Your reference :  
Our reference : EF13/3921; DOC18/59794-02  
Contact : Mr Andrew Helms; (02) 6332 7604

14 February 2018

**BORG PANELS – PROPOSED EXPANSION OF OBERON FACILITY (SSD 7016 MOD 1)**  
**EPA comment on Statement of Environment Effects**

Drawing
SURFACE WATER MANAGEMENT
SYSTEM

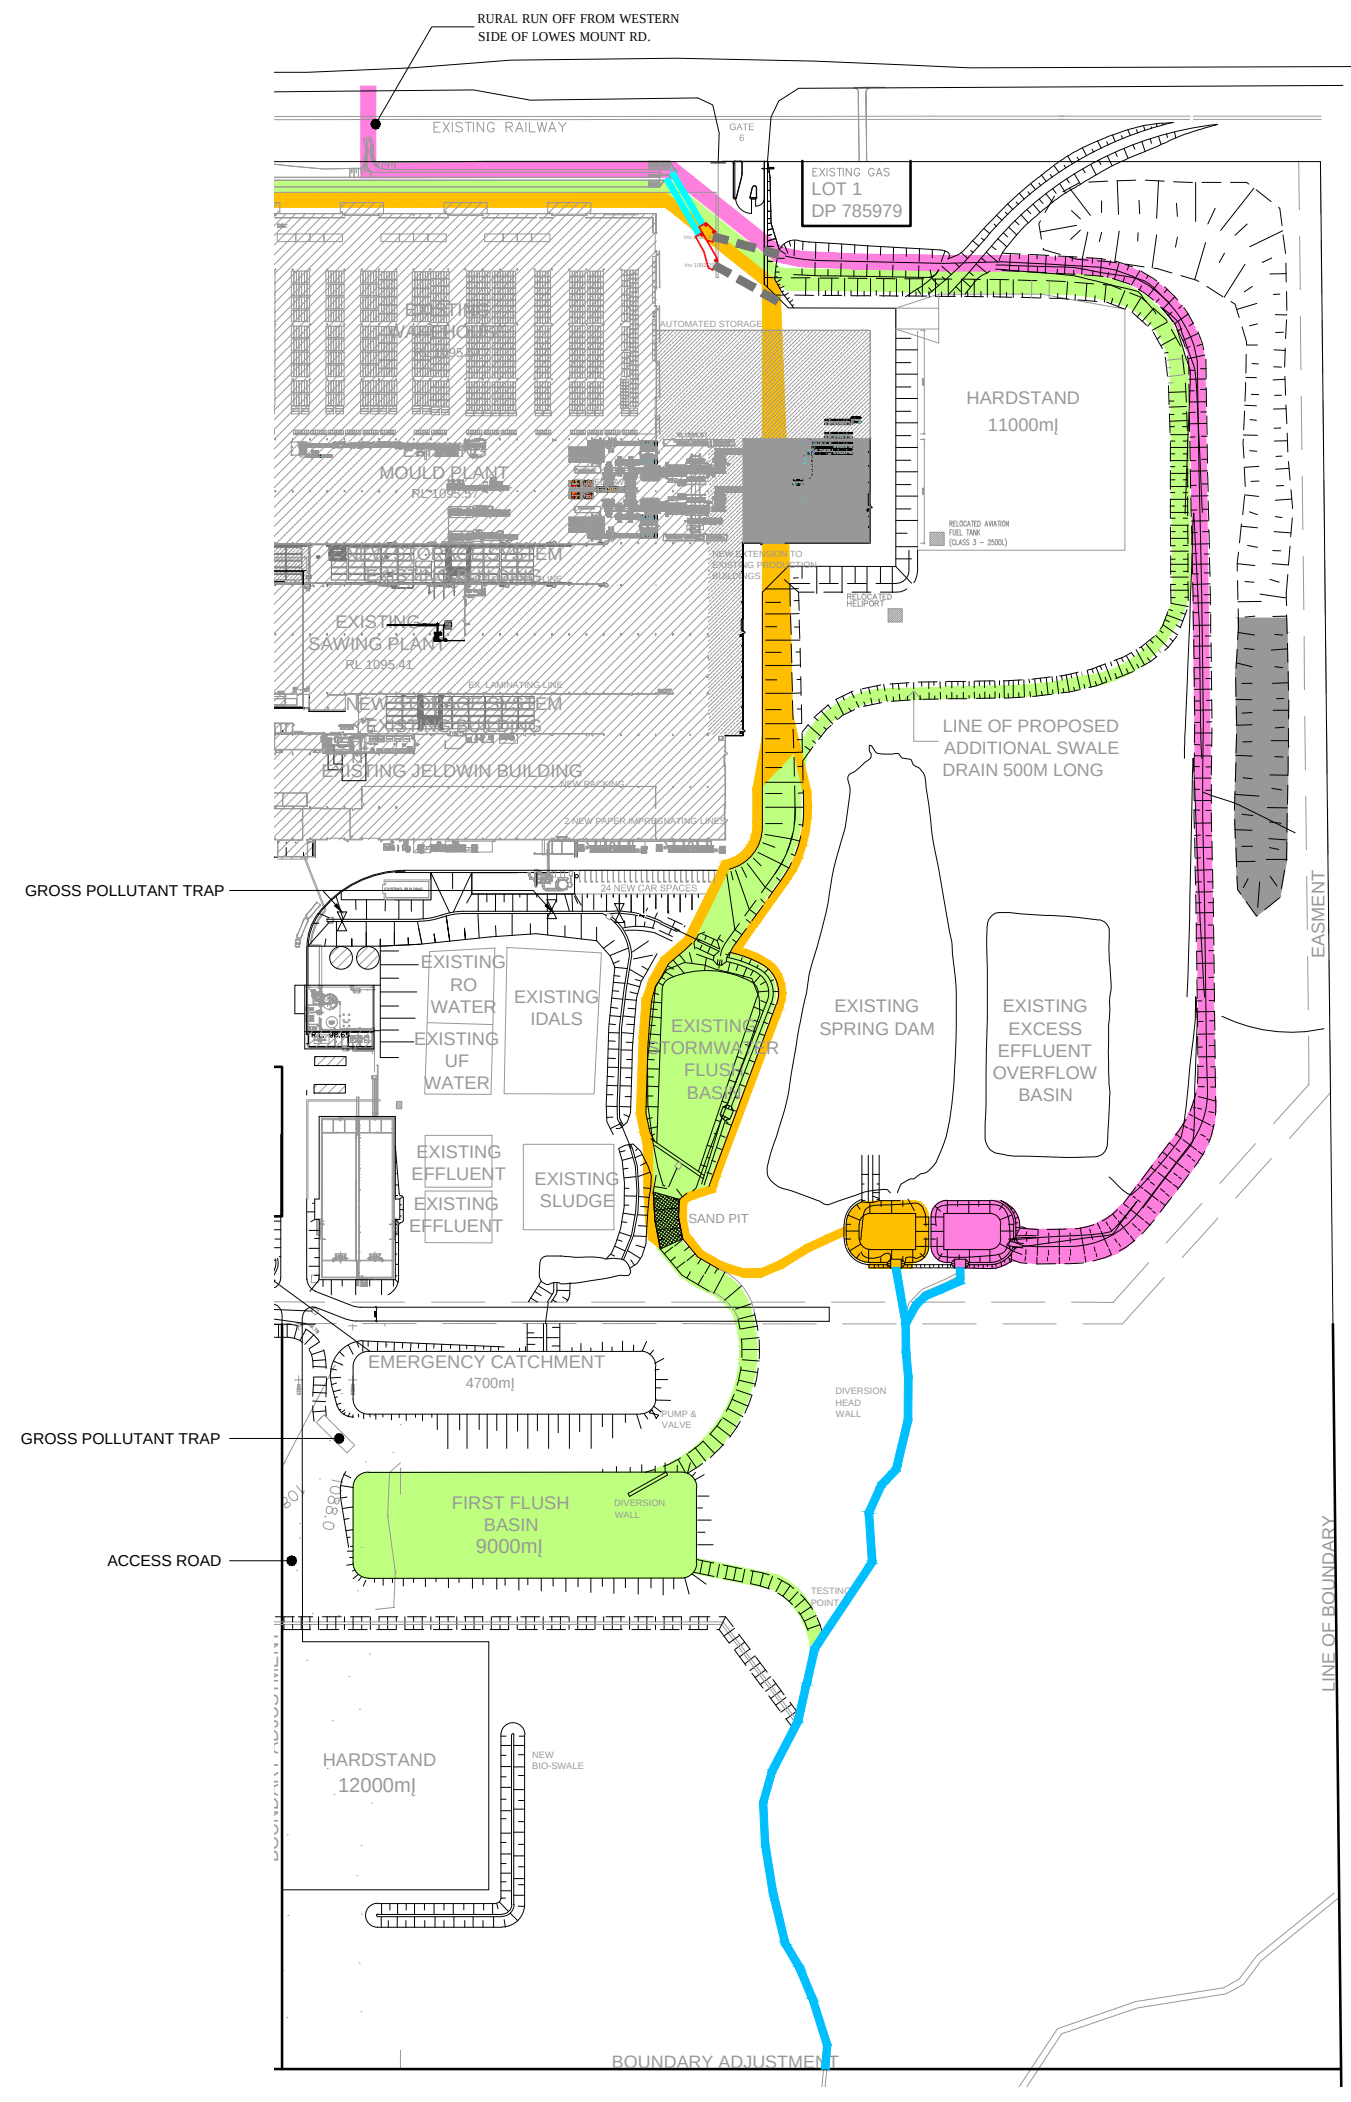
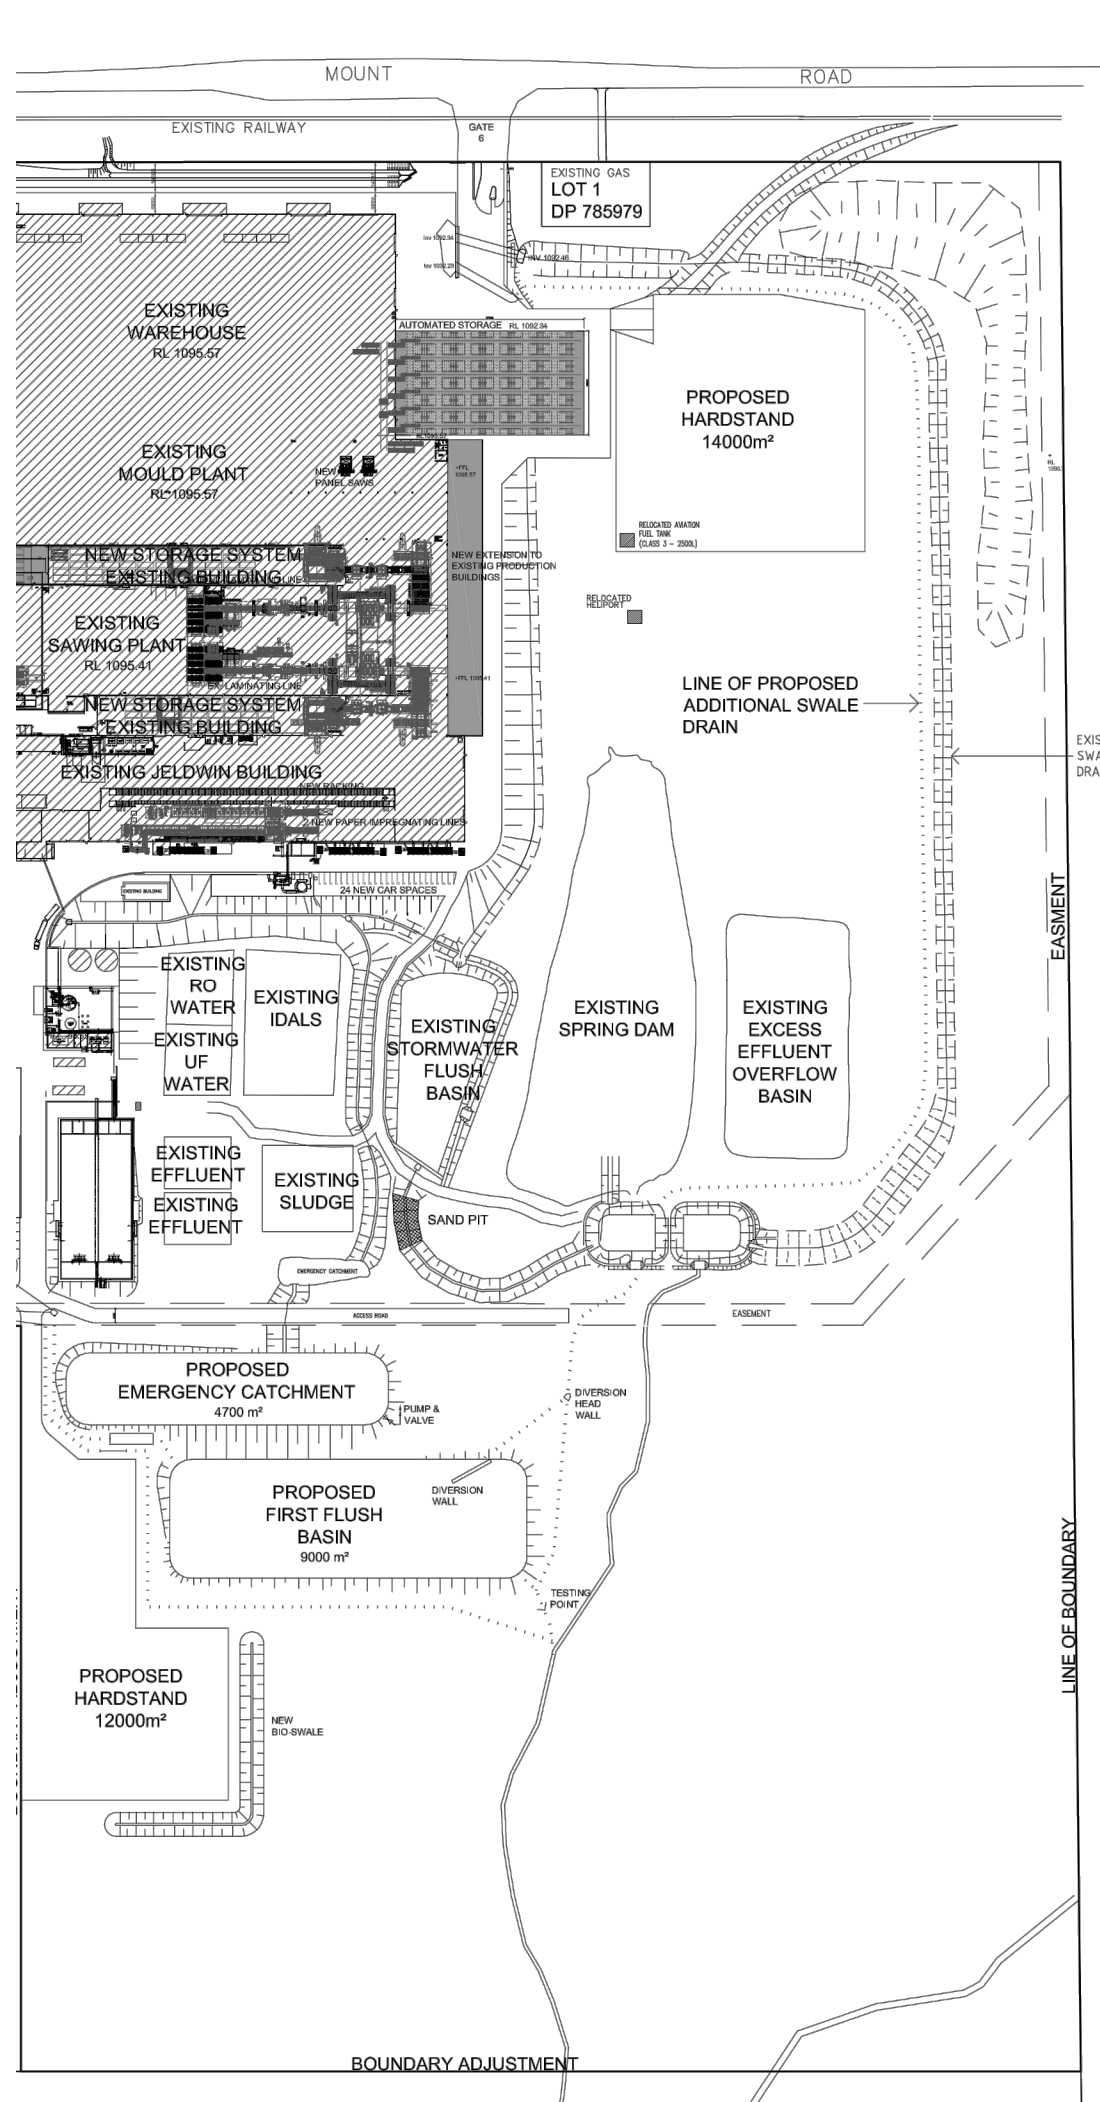
1. Build an acoustic wall to the specifications described in Section 2.1 of Appendix A. The EPA recommends that this acoustic wall be positioned so that it abuts the Material Handling Building, such that there is no gap between the commencement of the wall and the building.
2. That the Erosion and Sediment Control Plan prepared under consent condition C2 of SSD 7016 is updated to reflect the proposed changes described in the SEE for the modification application.
